Our ref: NO/2018/110834/01-L01
Your ref: 3/2018/0423
Date: 21 June 2018

NON-MATERIAL AMENDMENT TO APPROVED OUTLINE PLANNING PERMISSION 3/2012/0179 (OUTLINE APPLICATION FOR A RESIDENTIAL DEVELOPMENT FOR THE ELDERLY, COMPRISING OF 37 BUNGALOWS AND 40 RETIREMENT APARTMENTS) TO ALLOW VARIATION OF CONDITIONS 15 AND 19 TO ALLOW THE FORMATION OF THE SITE ACCESS TO TAKE PLACE BEFORE THE COMPLETION OF THE FLOOD COMPENSATION SCHEME AND THE WILDLIFE POND

LAND AT ACCRINGTON ROAD, WHALLEY, CLITHEROE

ROAD ACCESS

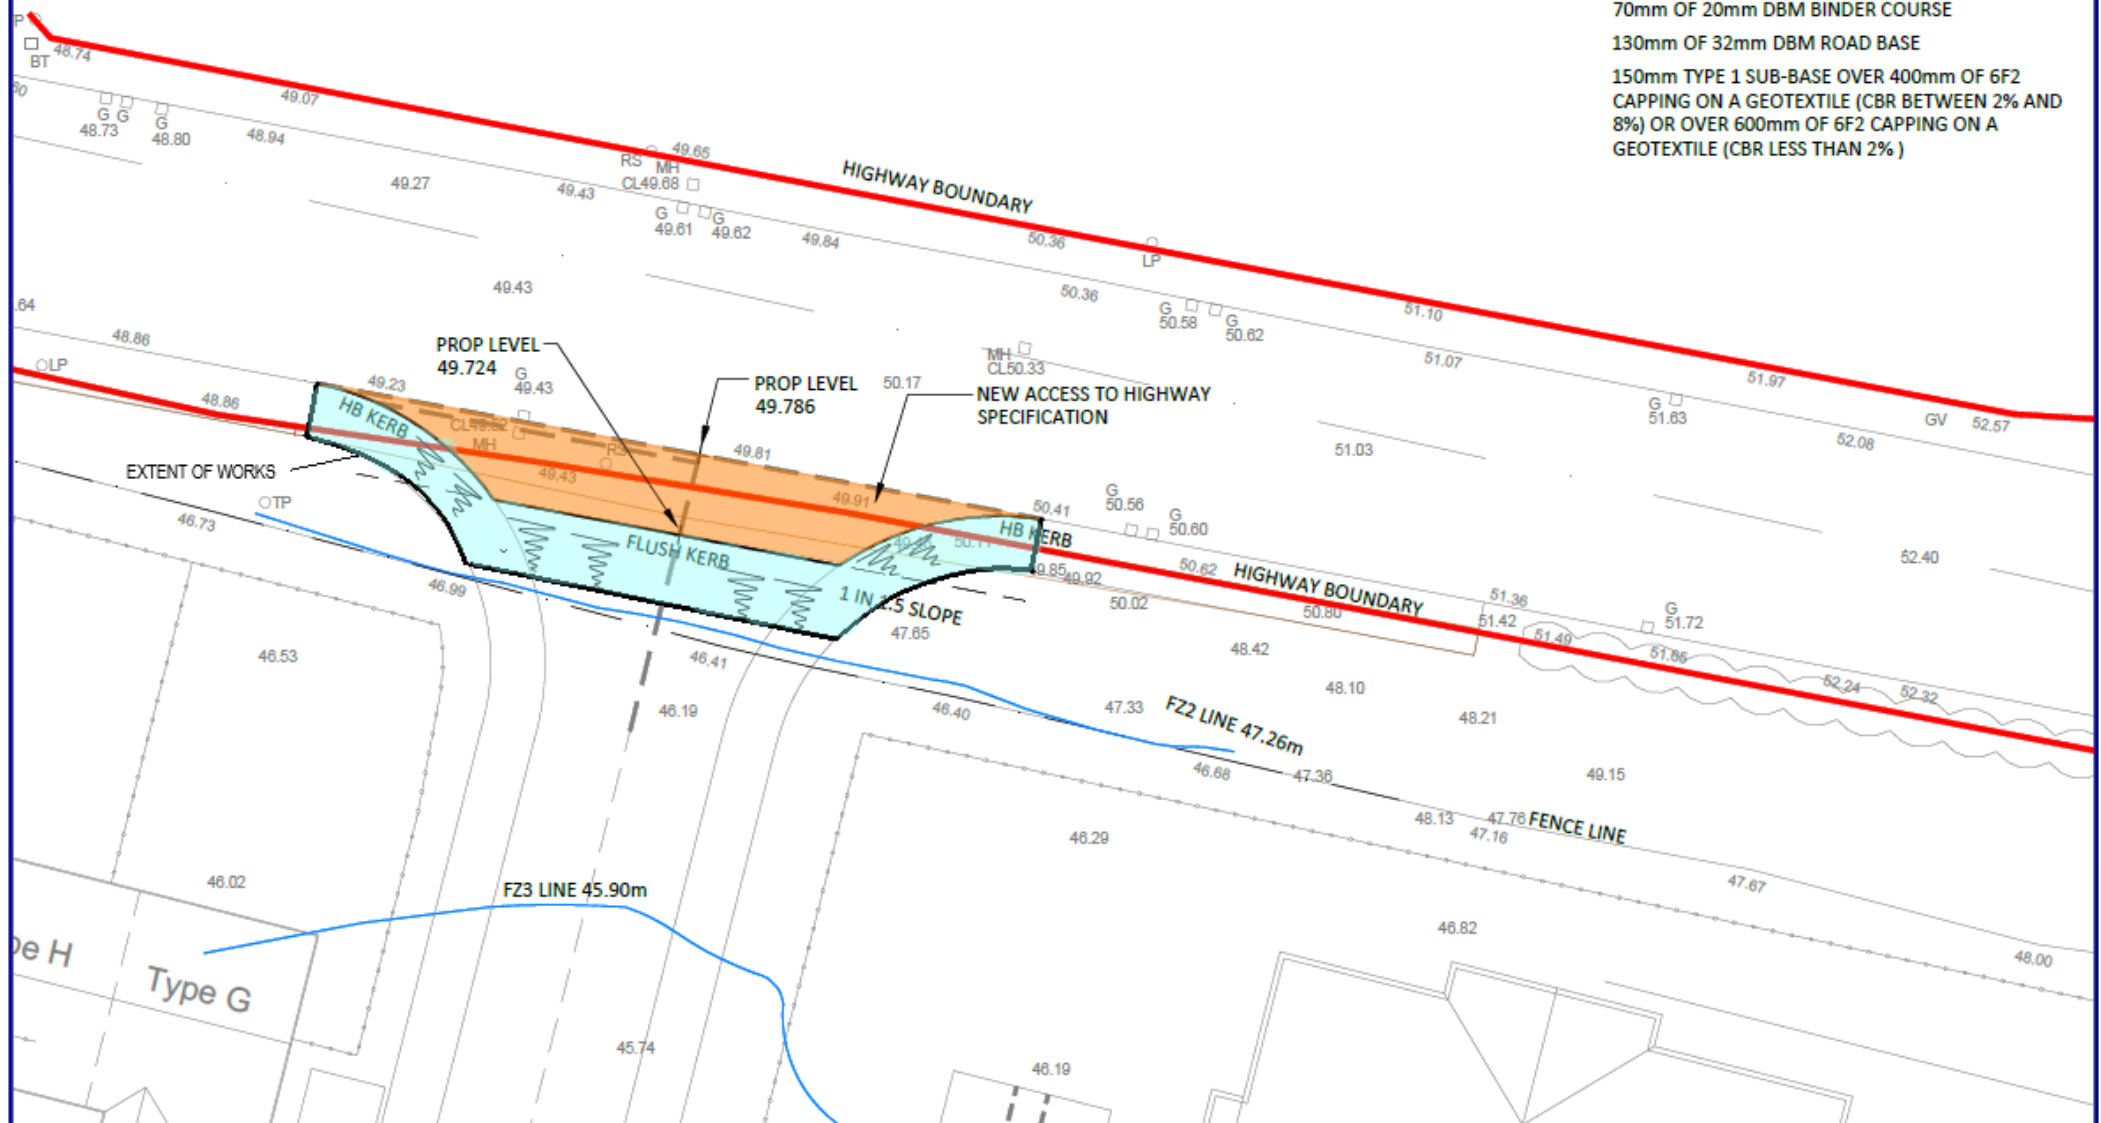
If the approved details are implemented in full, the boundary of the Section 38 works (drawing number C250-700 Rev A; dated 22/07/17) extends in to part of the site where works are necessary to implement the flood compensatory storage scheme necessary under Condition 15. There should be no development on parts of the site that will be subject to engineering works necessary to implement the flood storage scheme prior to the discharge of Condition 15. Any works in these area prior to the discharge of Condition 15 could impact on flood risk.

Can the revised wording be changed to more precisely detail what development will occur and where, prior to the implementation of the compensatory flood storage scheme? For example, the condition could specify that the development will be limited to the creation of the highway / site entrance in to the site up to 5 metres from the carriageway boundary on Whalley Road in accordance with details approved on

approved on 8 December 2017? This would ensure that any development to keep the permission extant will not impact on the works necessary to provide the compensatory flood storage scheme and the amended Condition 15 would remain enforceable.
